Application Ref:	3/2025/0680			 Ribble Valley Borough Council www.ribblevalley.gov.uk
Date Inspected:	24/06/24	Site Notice:	N/A	
Officer:	LW			
DELEGATED ITEM FILE REPORT:				APPROVAL

Development Description:	Proposed garage conversion.
Site Address/Location:	12 Northcote Park, Langho, BB6 8FB.

GARAGE PROPOSED ELEVATION
AND FLOOR PLAN

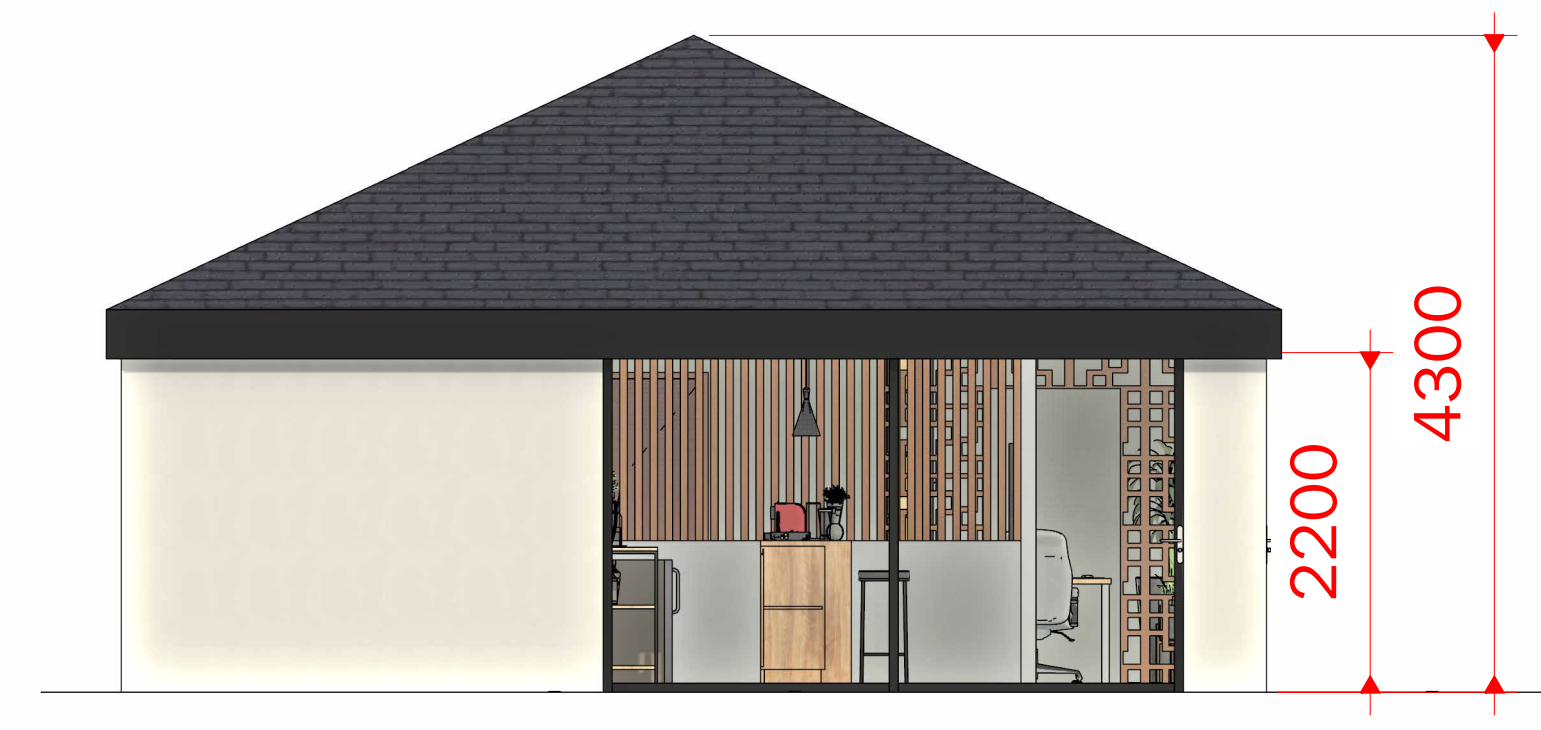
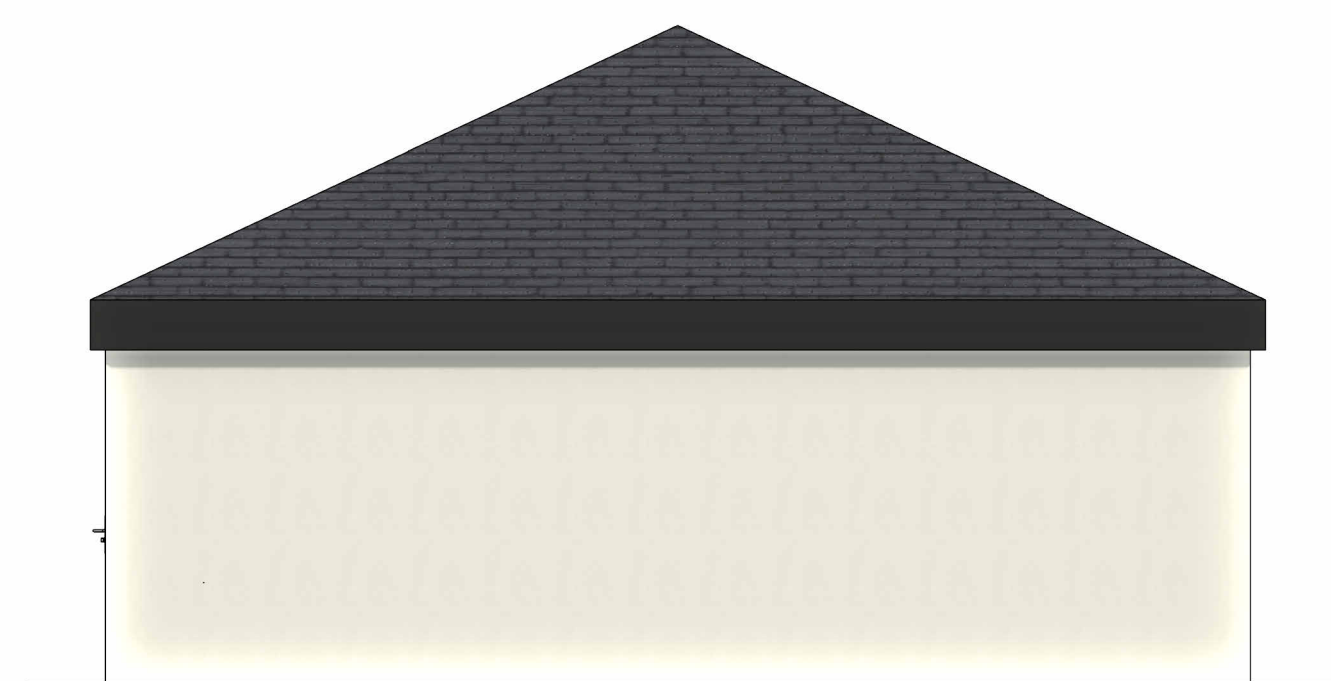
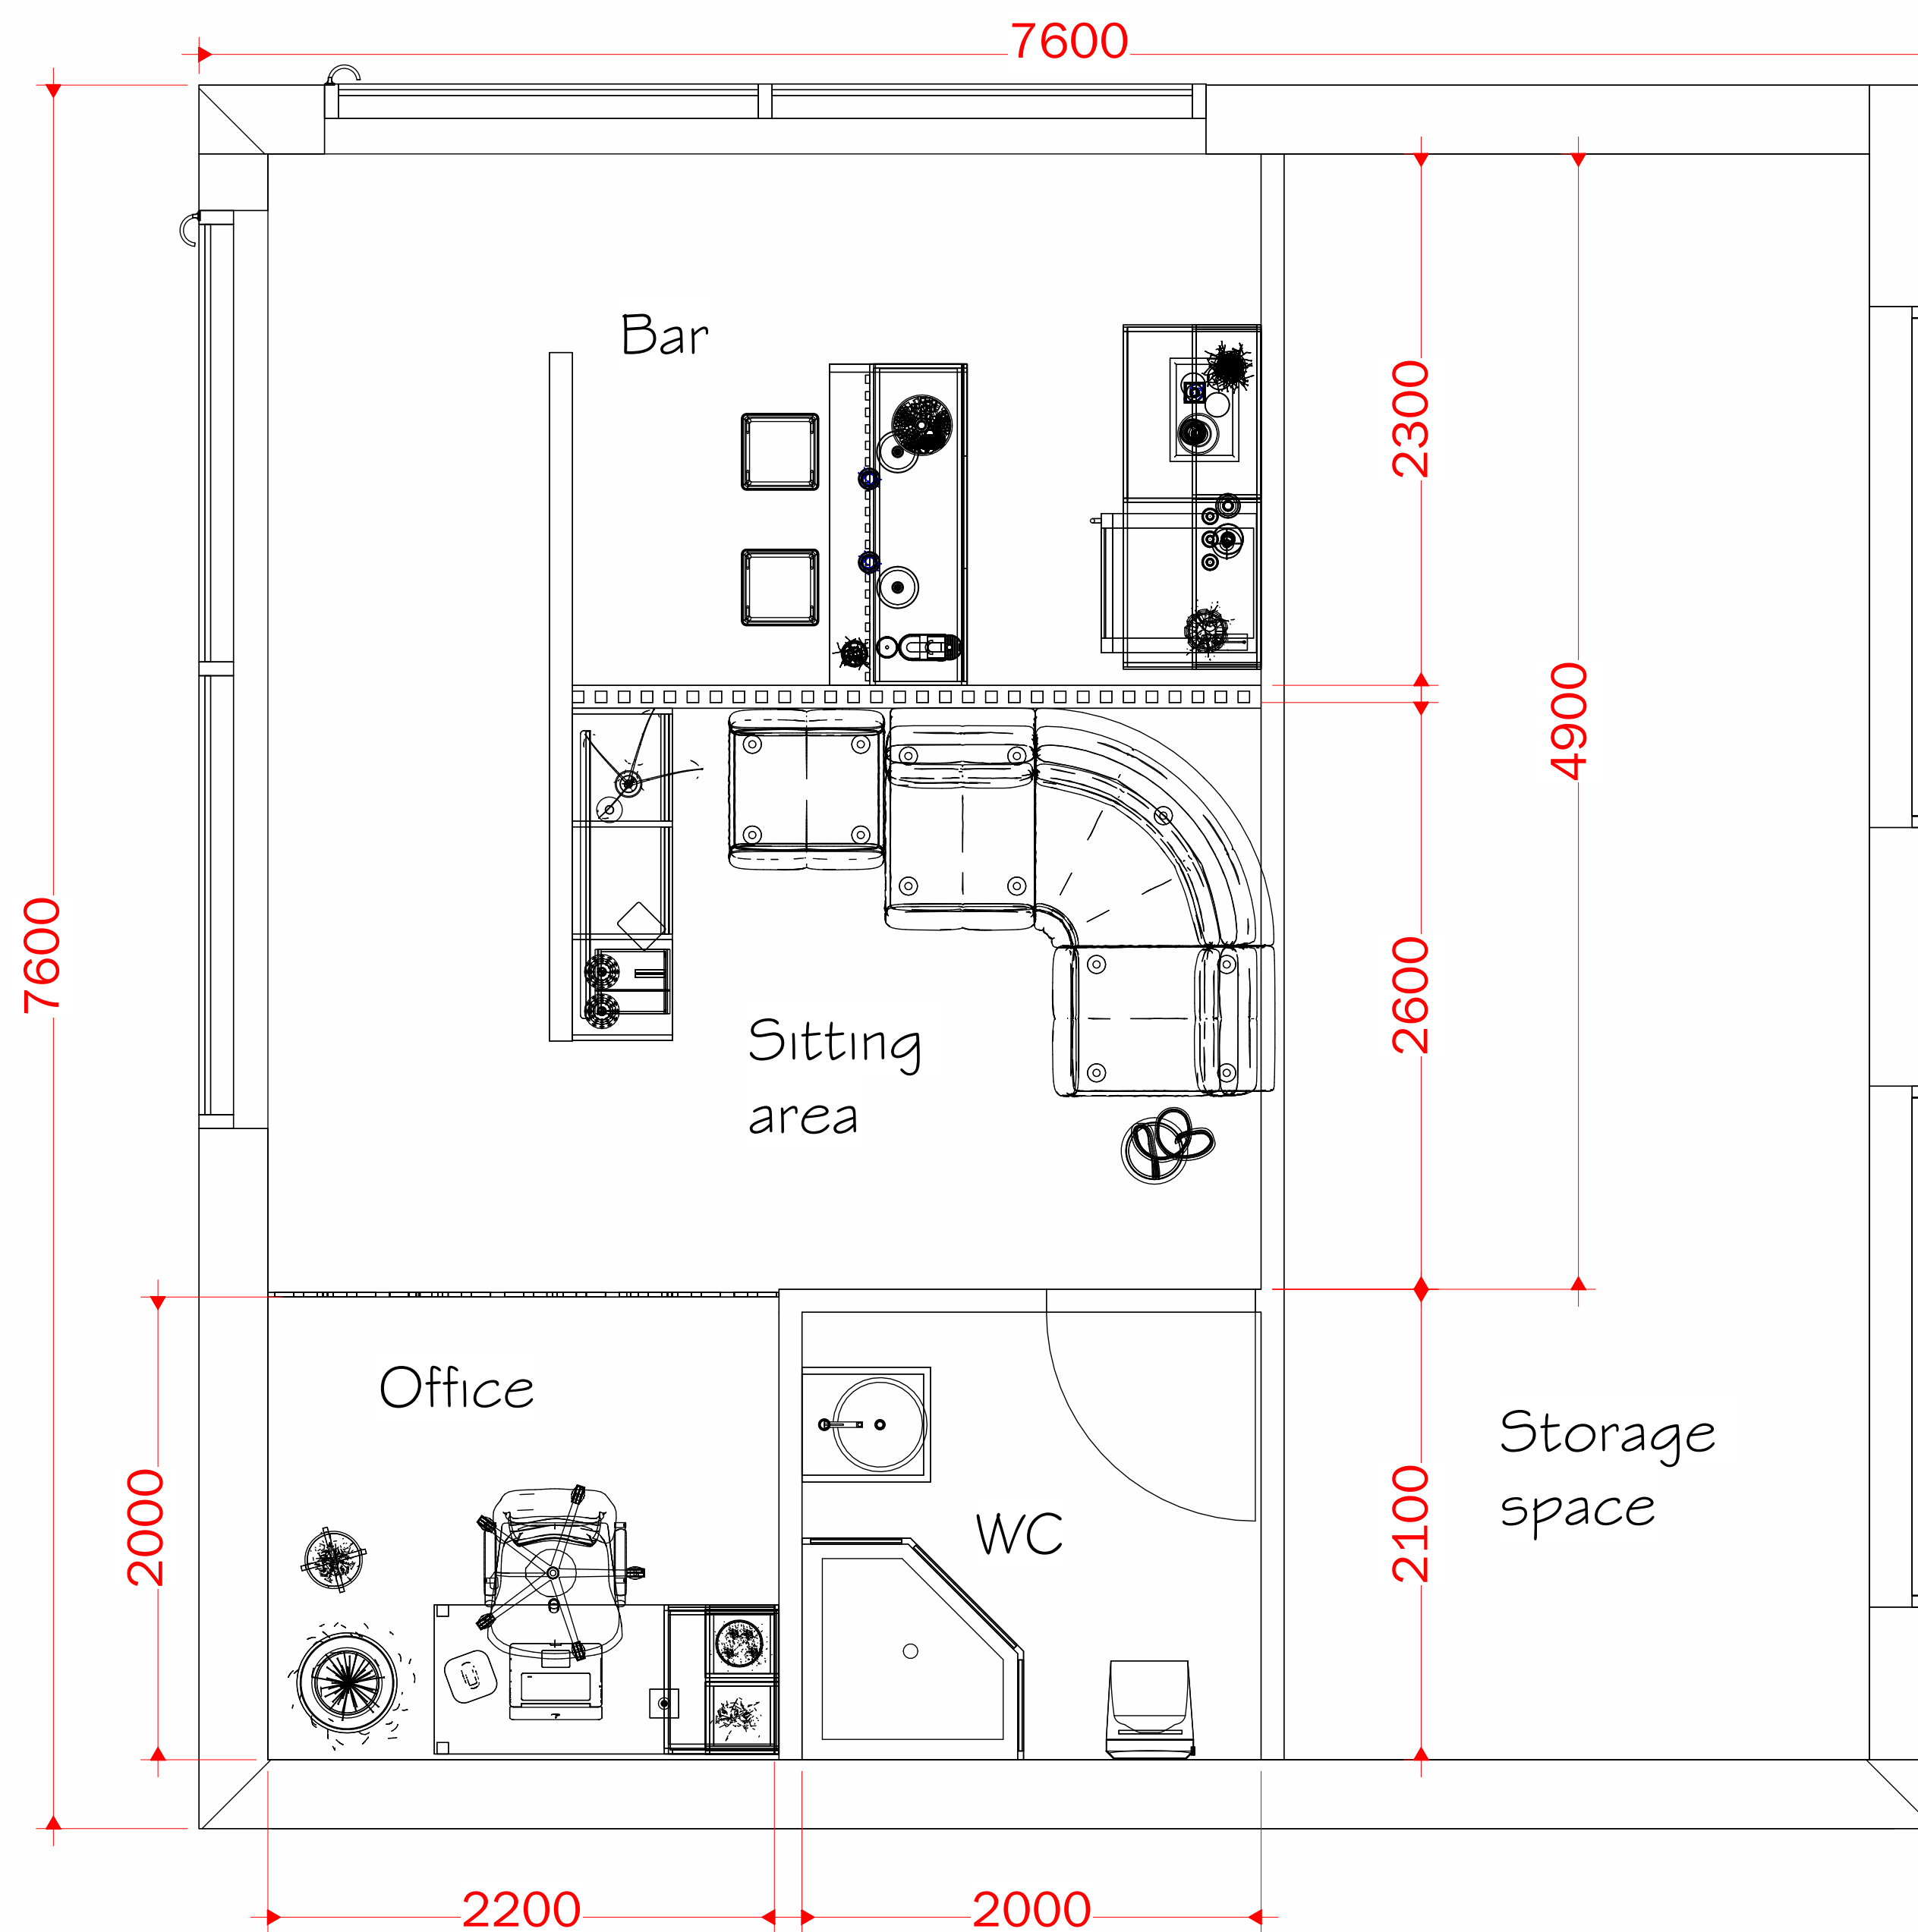
As part of the conversion works the existing garage doors would be retained, however glazed sliding doors would be incorporated to the northern side and western rear elevations.

The openings proposed to the northern side and western rear elevation of the garage would provide views predominantly towards the private amenity space associated with the application property and therefore no new opportunities for direct overlooking or loss of privacy are anticipated in this respect.

In addition to this, the proposed conversion would not involve any increase in the footprint or height of the existing building. As such, no undue impact upon neighbouring residential receptors, by way of overshadowing, loss of outlook or daylight, would be resultant.

The proposed conversion would include minor alterations to the existing garage structure, including the addition of glazed sliding doors to the side and rear elevations. These openings would not be visible from the adjacent public realm and as such, their impact upon the immediate and wider locality would be negligible.

PROPOSED SITE PLAN

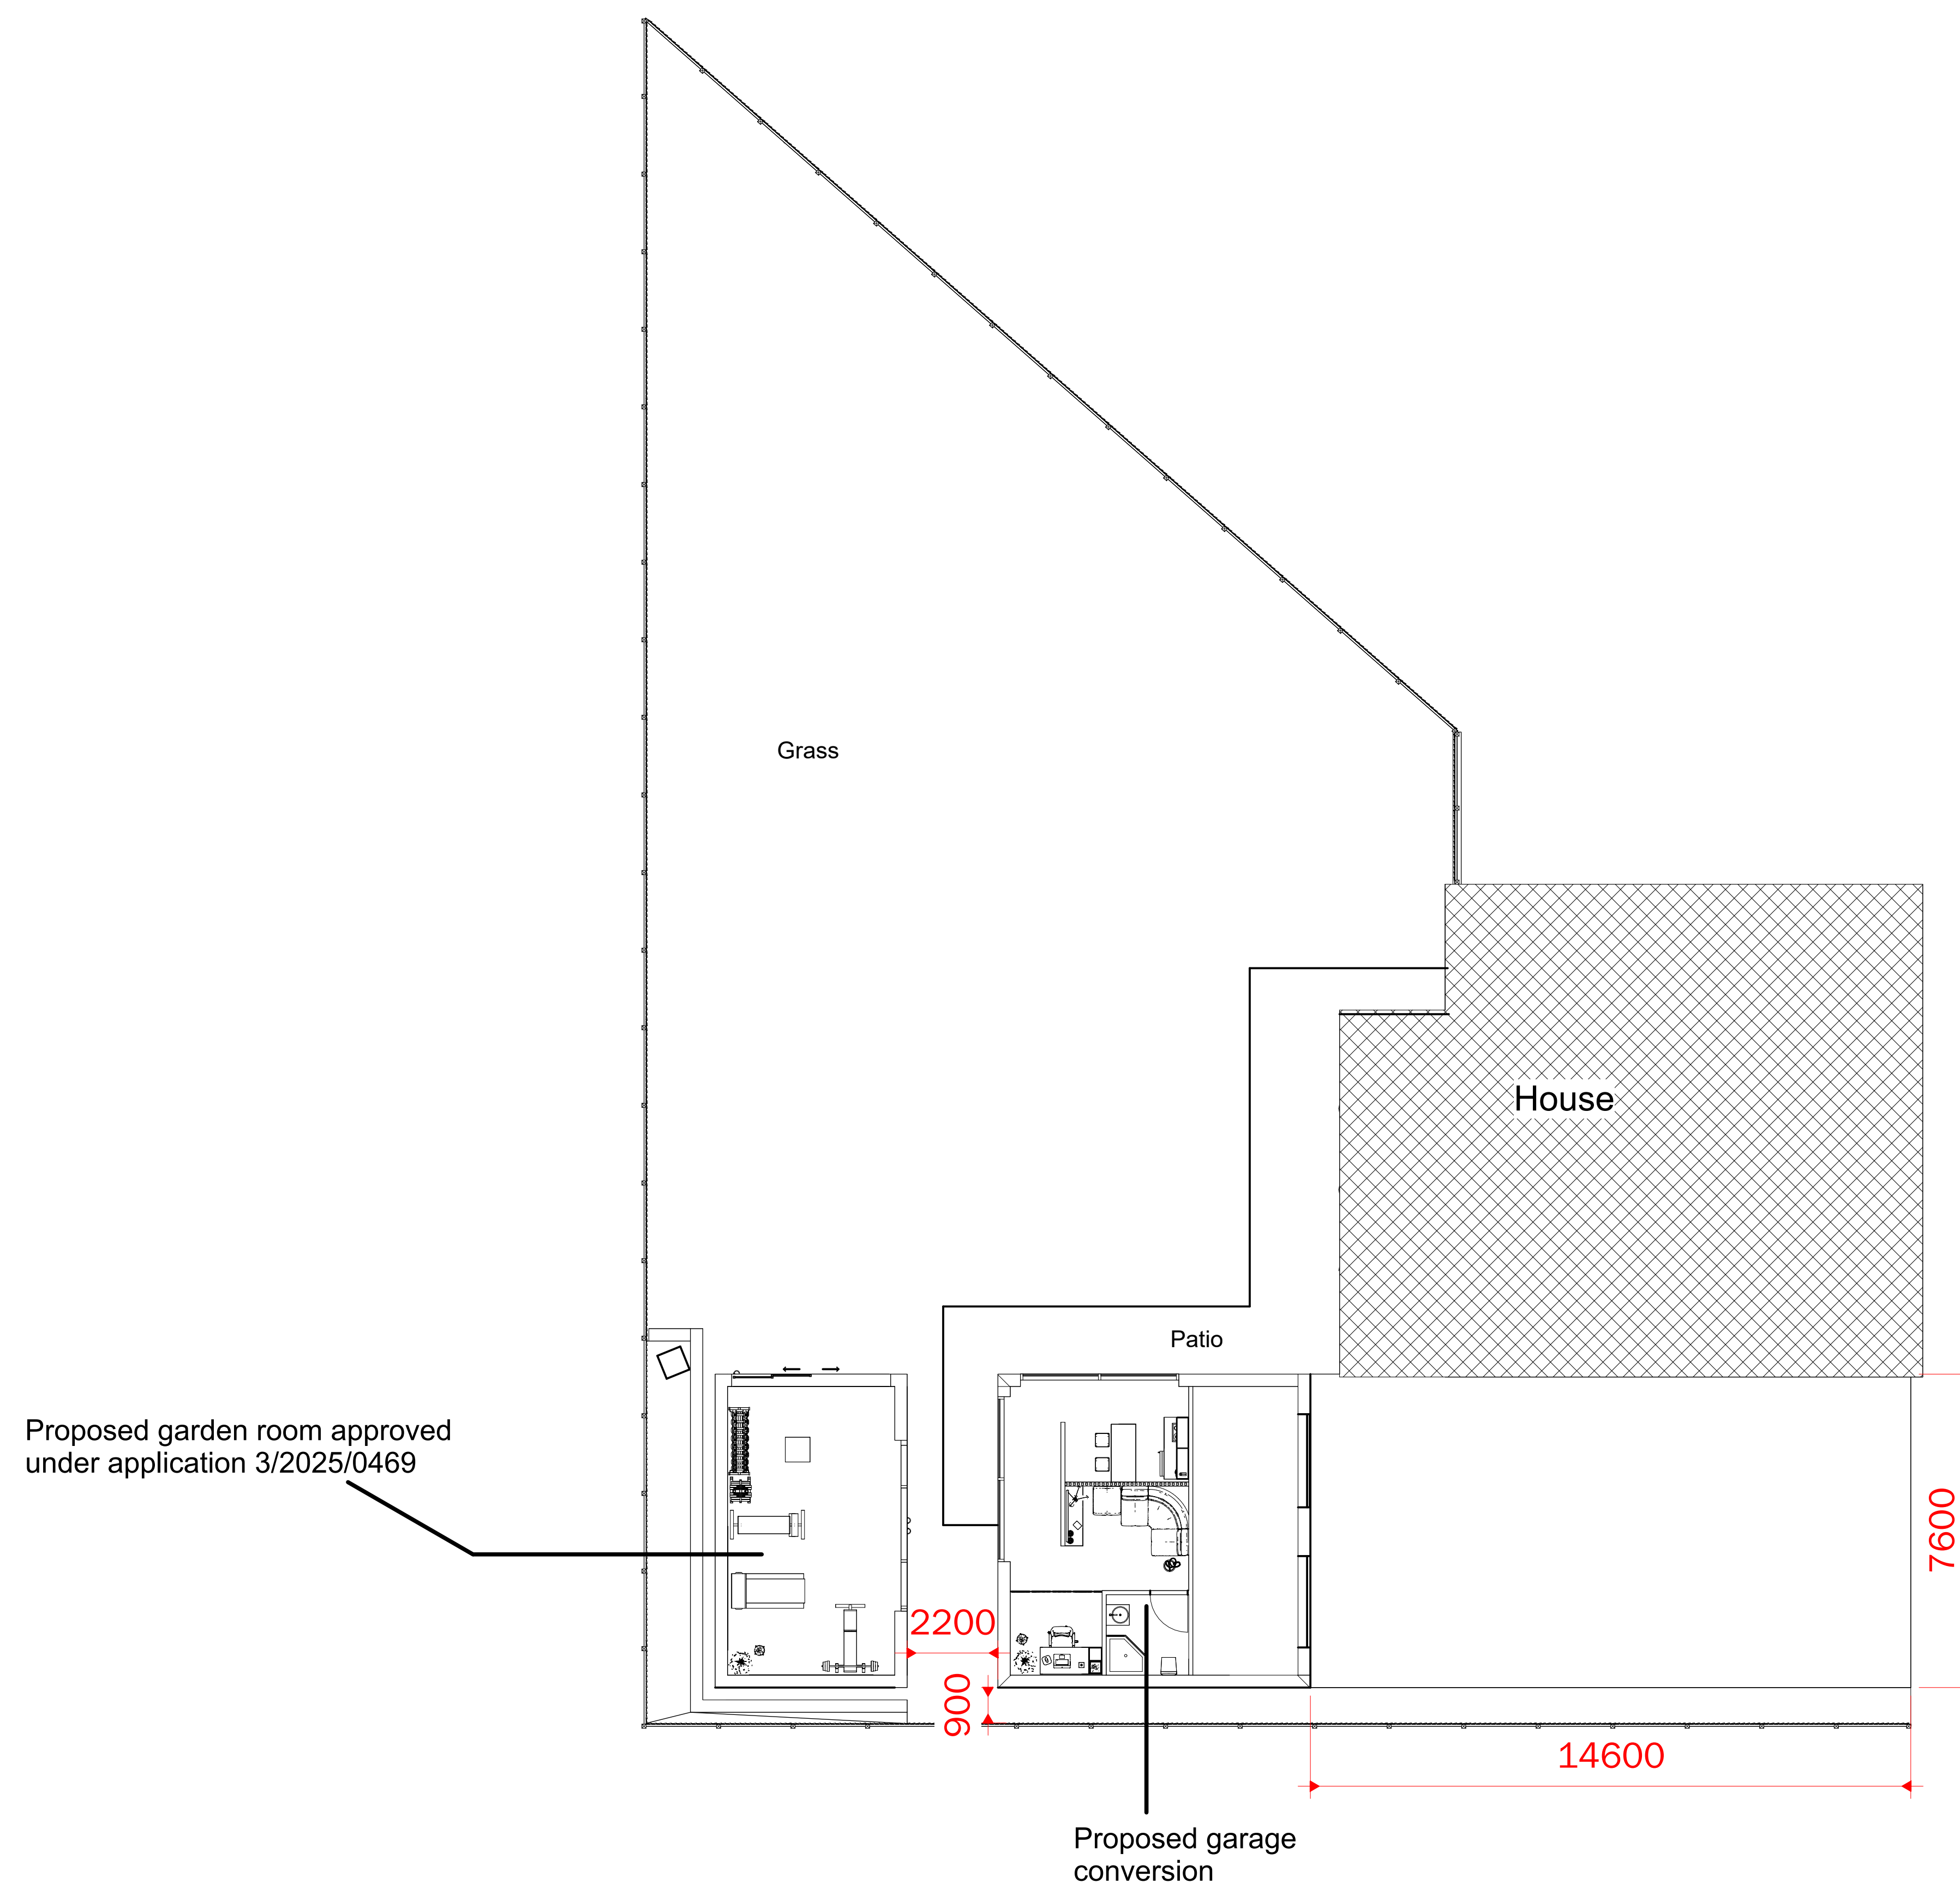
The proposal has been subject to review by Lancashire County Council Highways. The Local Highway Authority (LHA) note that the site access will remain unaltered following the proposal and whilst the garage will be removed, the existing driveway will be retained, providing four off-street parking spaces. As such, the LHA does not raise an objection regarding the proposed development and are of the opinion that the proposal would not have a significant impact on highway safety or capacity in the immediate vicinity of the site subject to a condition restricting the use of the building solely for domestic purposes.
